**CITY OF ALBUQUERQUE
ADMINISTRATIVE APPROVAL (AA)- SITE DEV PLAN AMENDMENT
ROUTING & REVIEW SHEET**

APPLICATION #: 10022	PROJECT #: 1009168
PROJECT NAME: Richfield Park	
APPLICANT or AGENT: Kathleen Loudermilk	
PHONE # and E-MAIL: 573-5583	
ZONE ATLAS PAGE: C-17	
ADMINISTRATIVE APPROVAL (AA) for:	<input type="checkbox"/> EPC CASE <input checked="" type="checkbox"/> DRB CASE

DESCRIPTION OF REQUEST: ADD DECORATIVE WALL & WASH PAD

**MASTER UTILITY
PLAN**

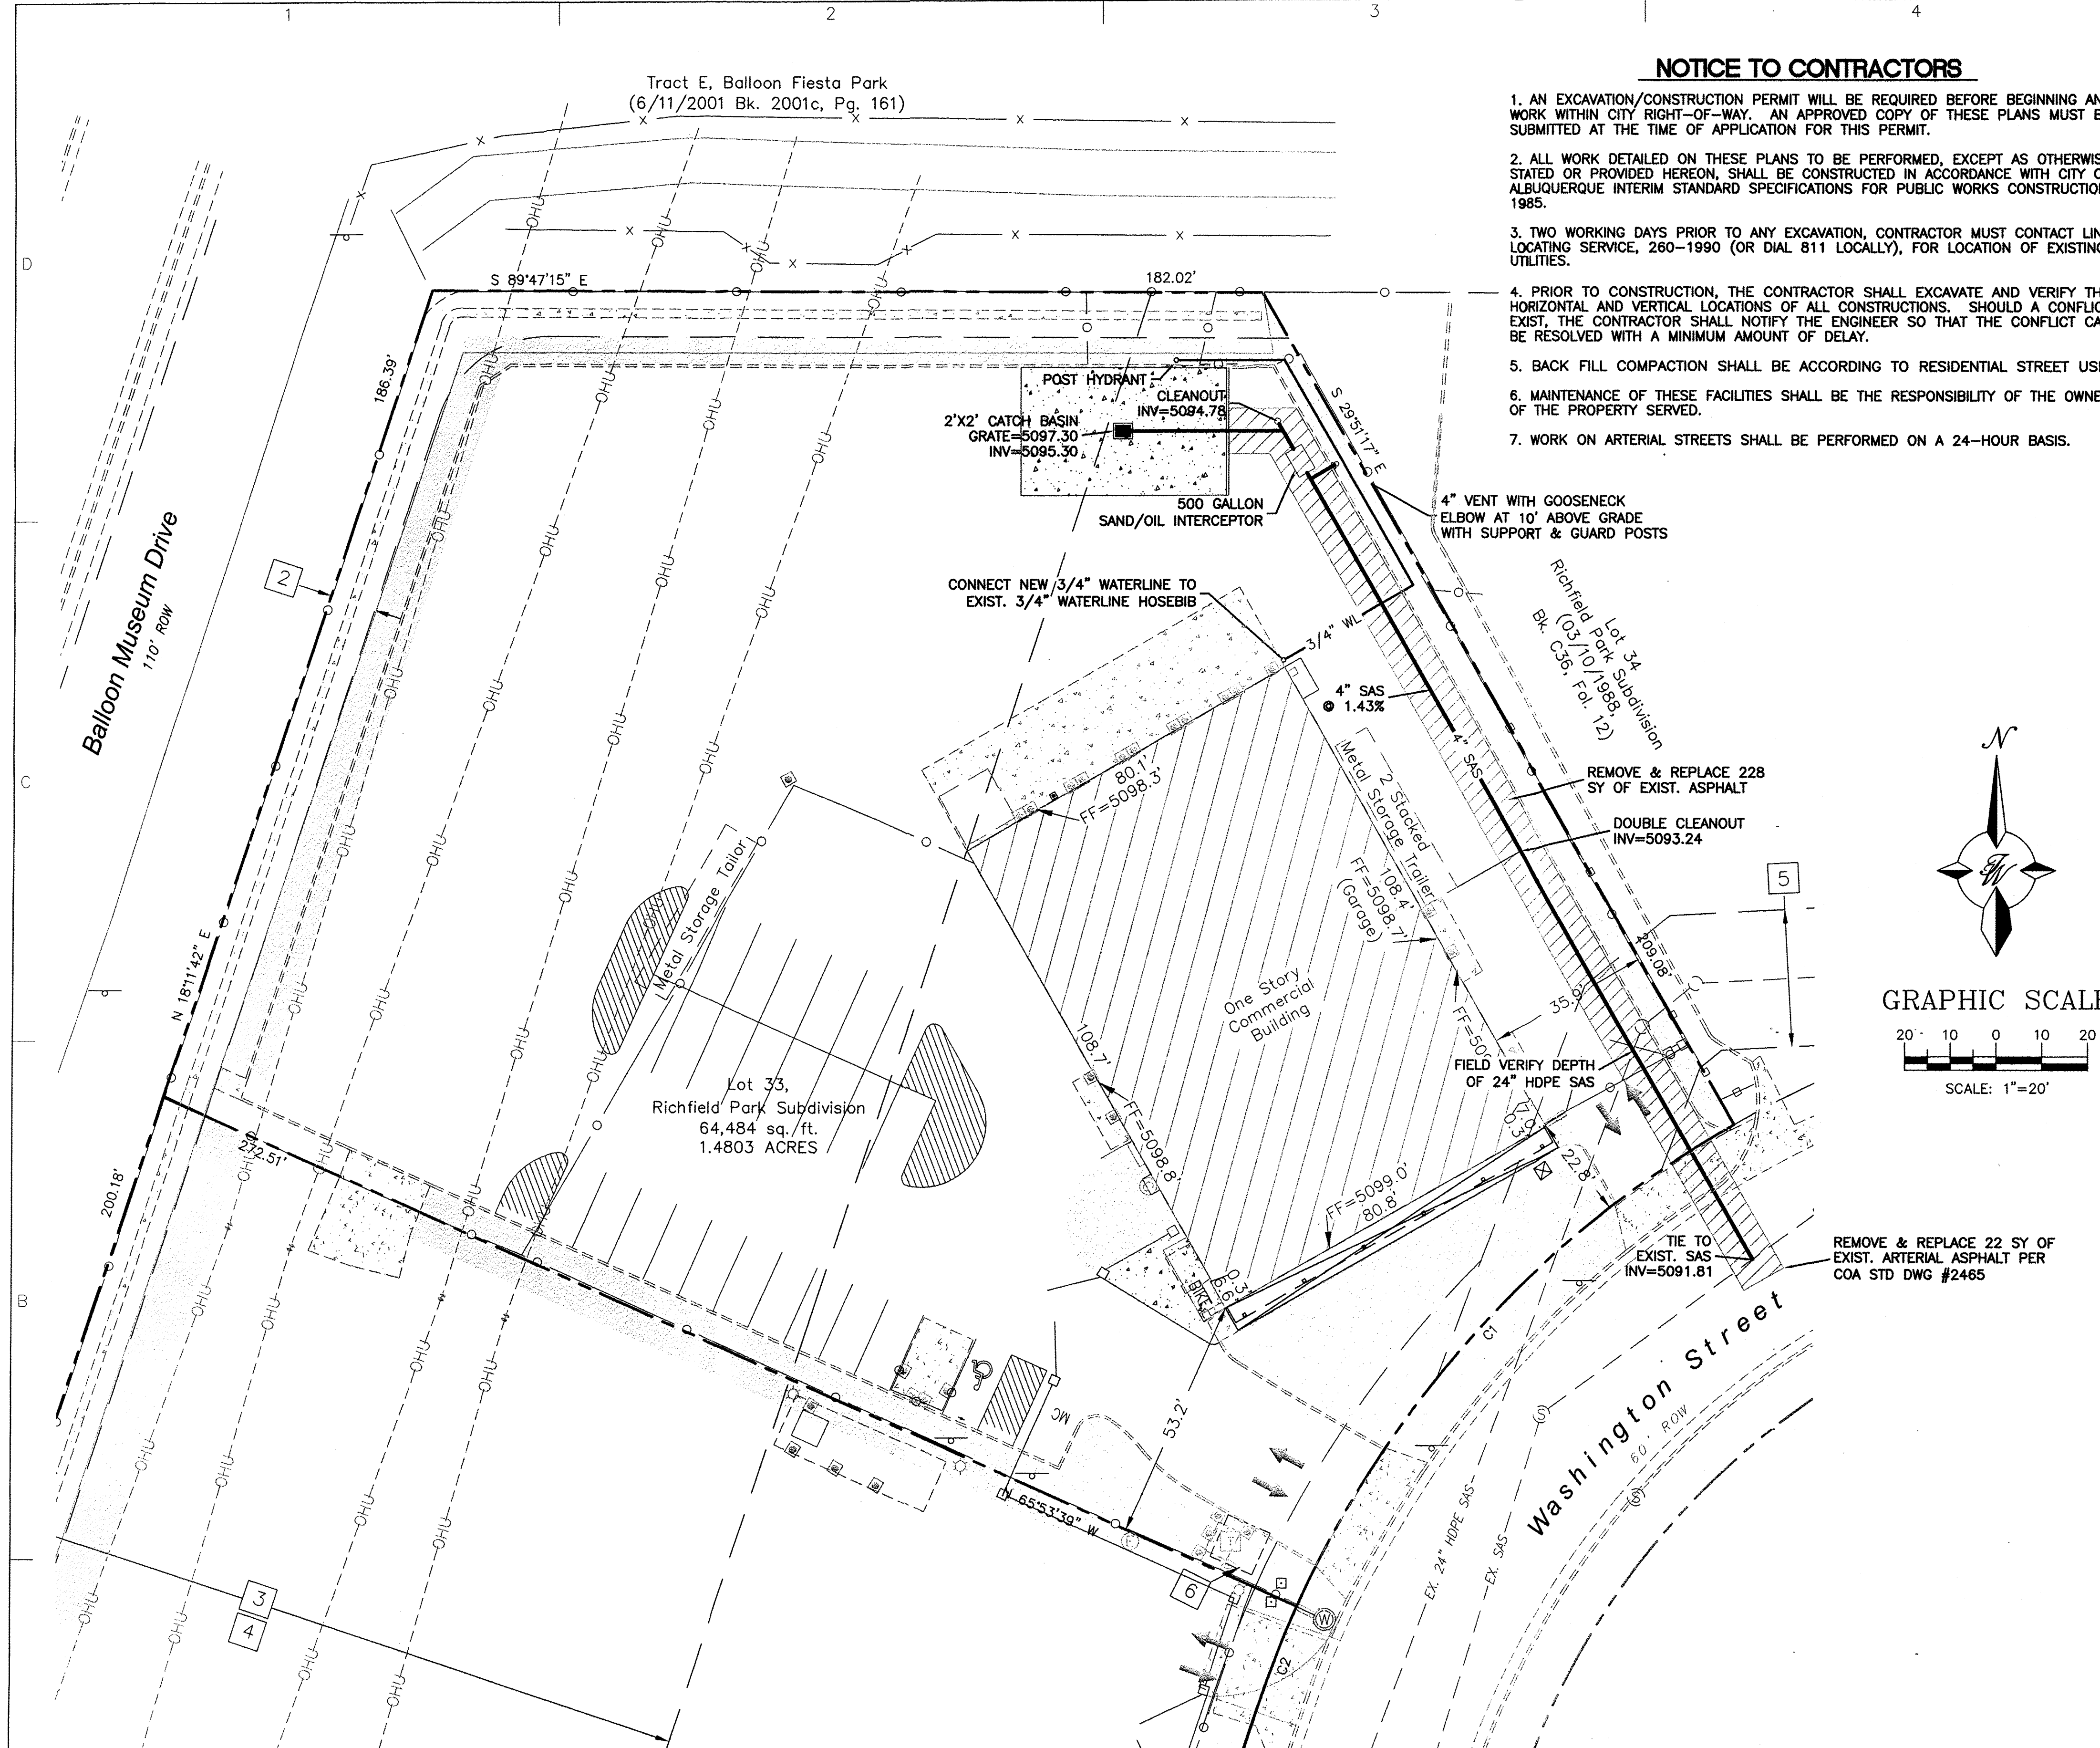
UTILITIES (505) 924-3989	DATE RECEIVED:
PLANS DISAPPROVED: JH	DATE: 6-6-12
PLANS APPROVED: JH	DATE: 6-14-12
COMMENTS: PROVIDE A SWALE OR BURN TO PREVENT STORM WATER FROM ENTERING THE PROPOSED WASH PAD. A TAPPING PERMIT WILL BE REQUIRED FOR THE NEW SAS PIPE CONNECTION

SITE DEVELOPMENT PLAN

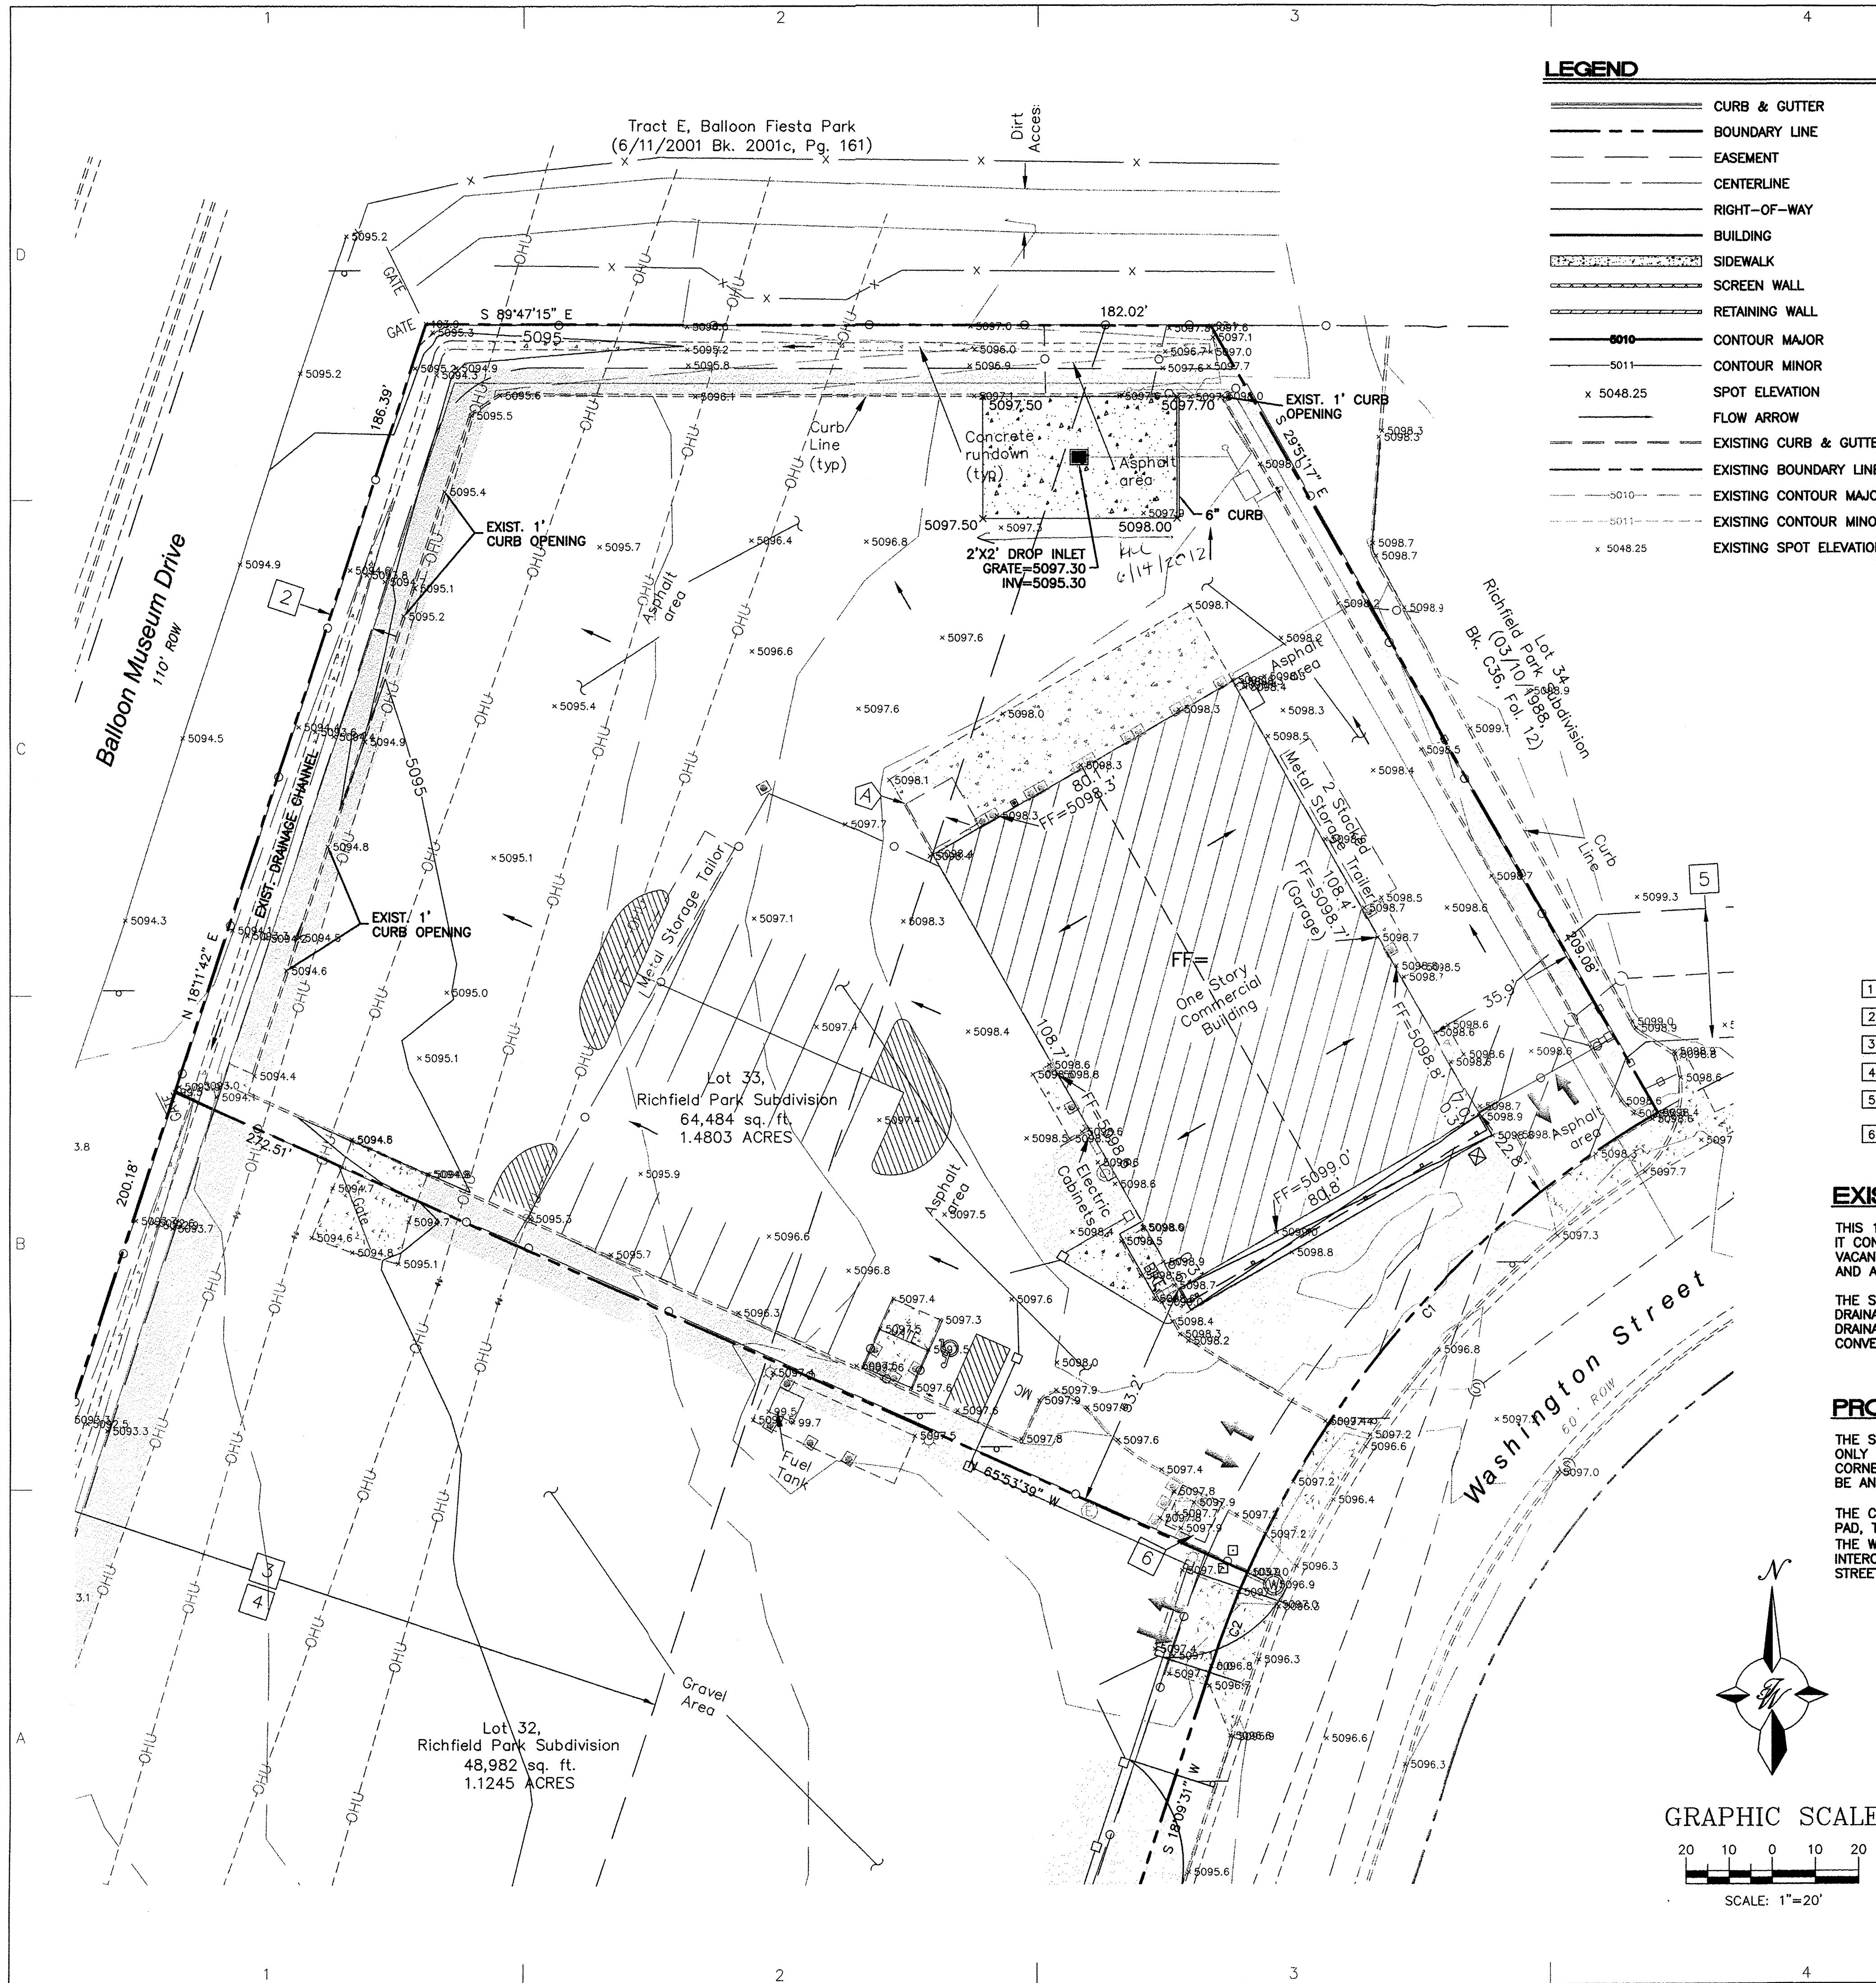
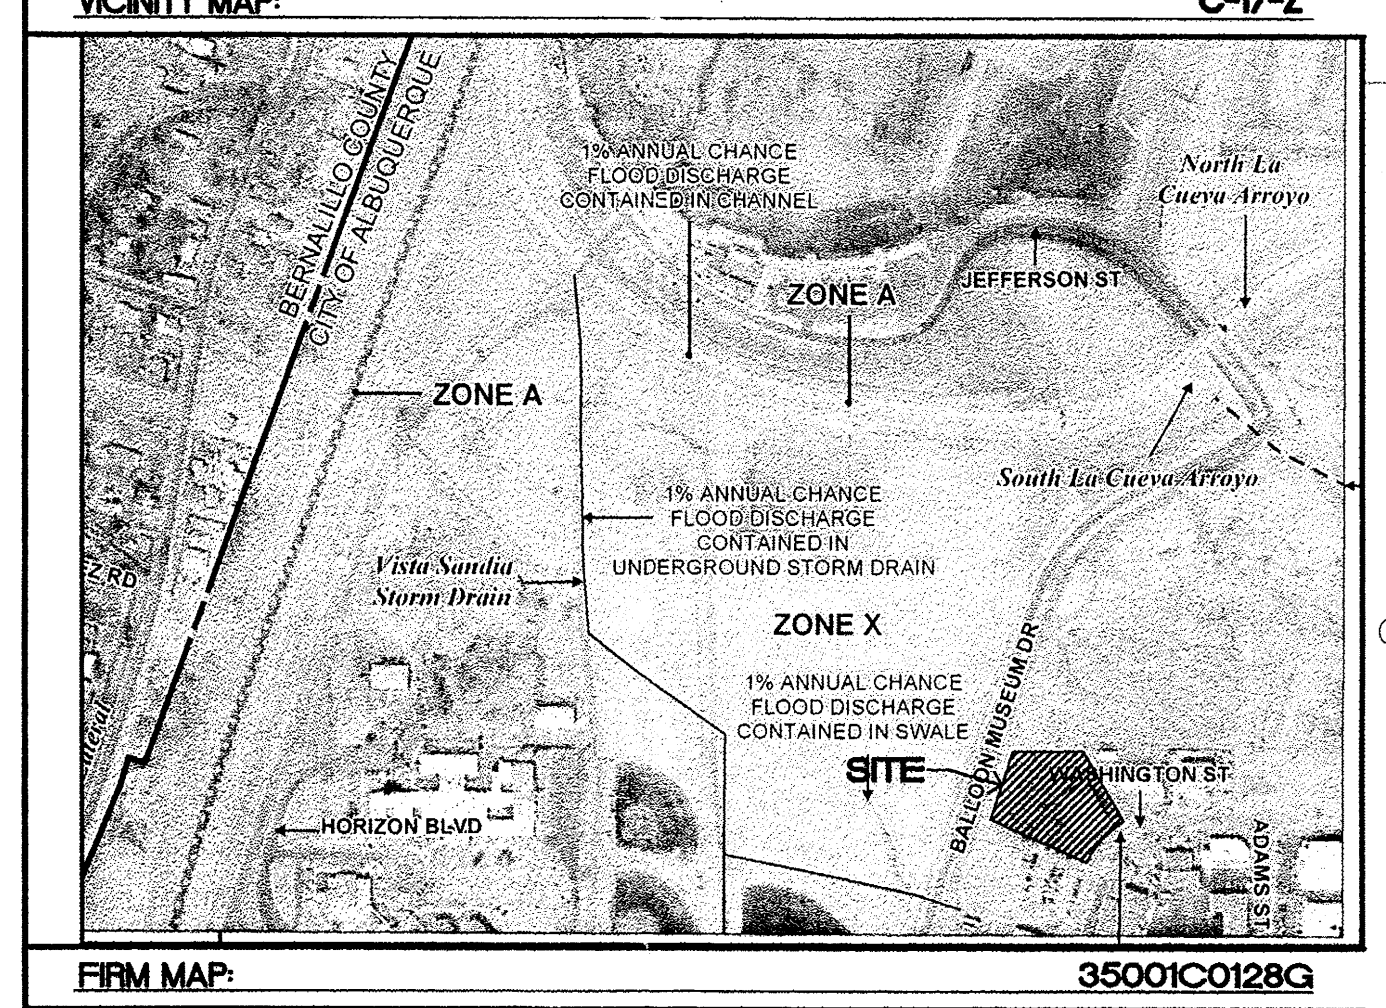
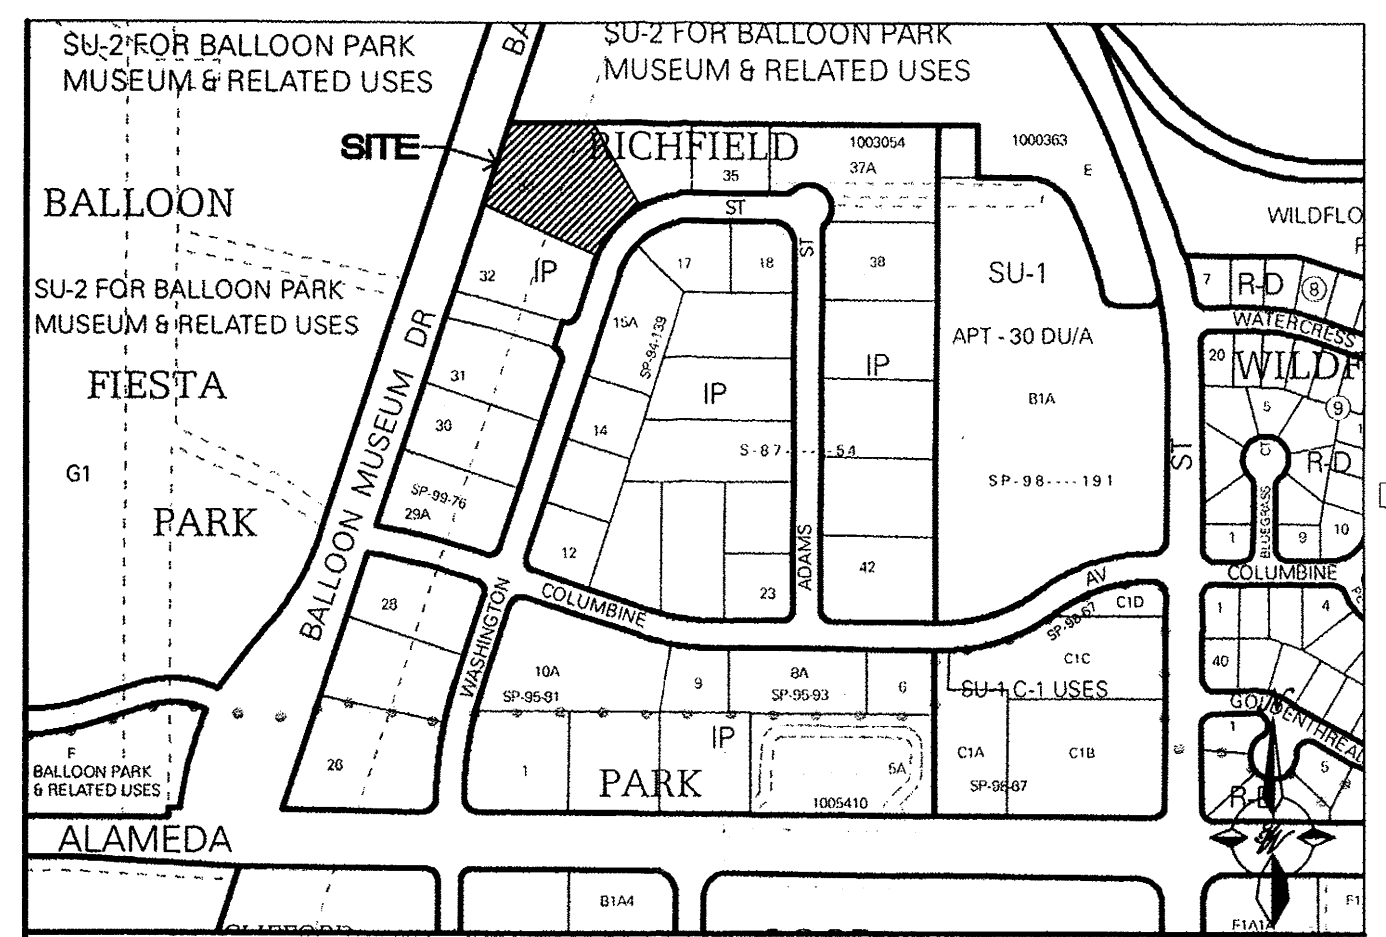
TRANSPORTATION (505) 924-3630	DATE RECEIVED:
PLANS DISAPPROVED: NSF	DATE: 06/06/12
PLANS APPROVED: NSF	DATE: 06/14/12
COMMENTS: Gate location is too far back from Washington, either relocate gate or provide vehicle turn around.
